Date 26 January 2024
Our Ref 24/00042/CLP

Town and Country Planning Act 1990 (As Amended)
42 Arundel Avenue, Ewell, Surrey
Lawful Development Certificate - Proposed Use: Widening of existing dropped kerb and crossover

Location Plan

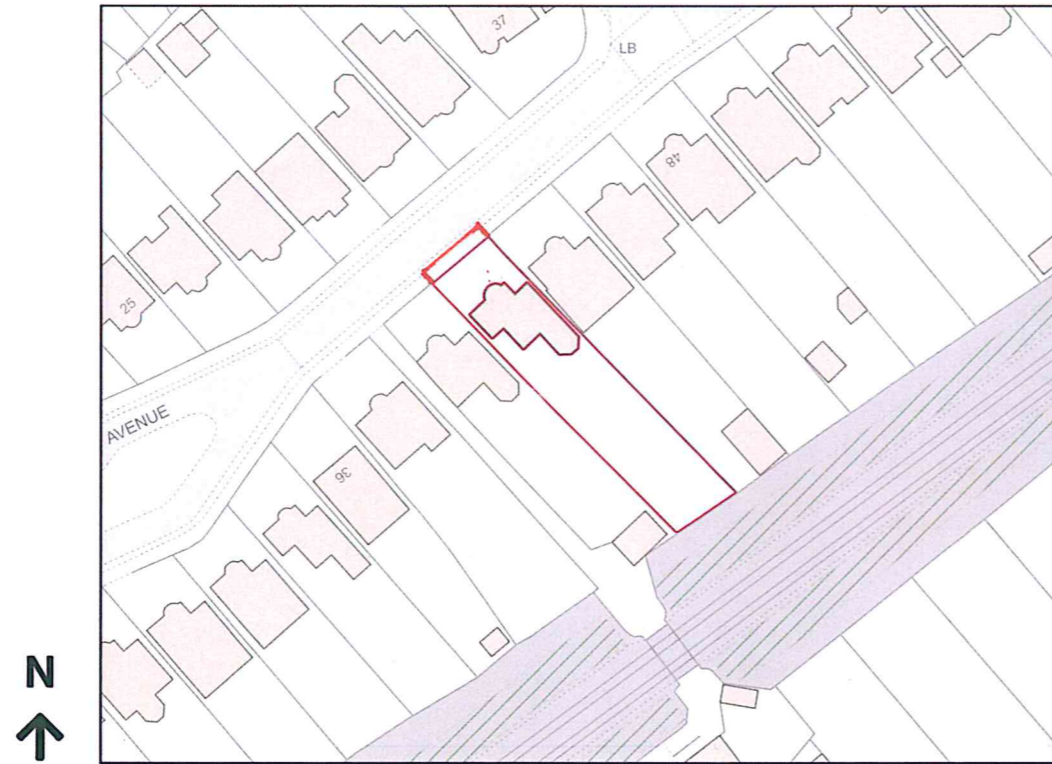
1 LOCATION PLAN AND BLOCK PLAN - The application site should be edged clearly with a red line on the Location Plan and Block Plan and should include all land necessary to carry out the proposed development which includes land required for access to the site from a public highway. As the proposal involves the extension of an existing dropped kerb, this needs to be included within the red line of the Location Plan and Block Plan. In summary, the red line on the Location Plan and Block Plan you have already submitted, needs to be extended up to the public highway but to include the pavement. Please forward the amended documents by email directly to planningsupport@epsom-ewell.gov.uk quoting the application reference above.
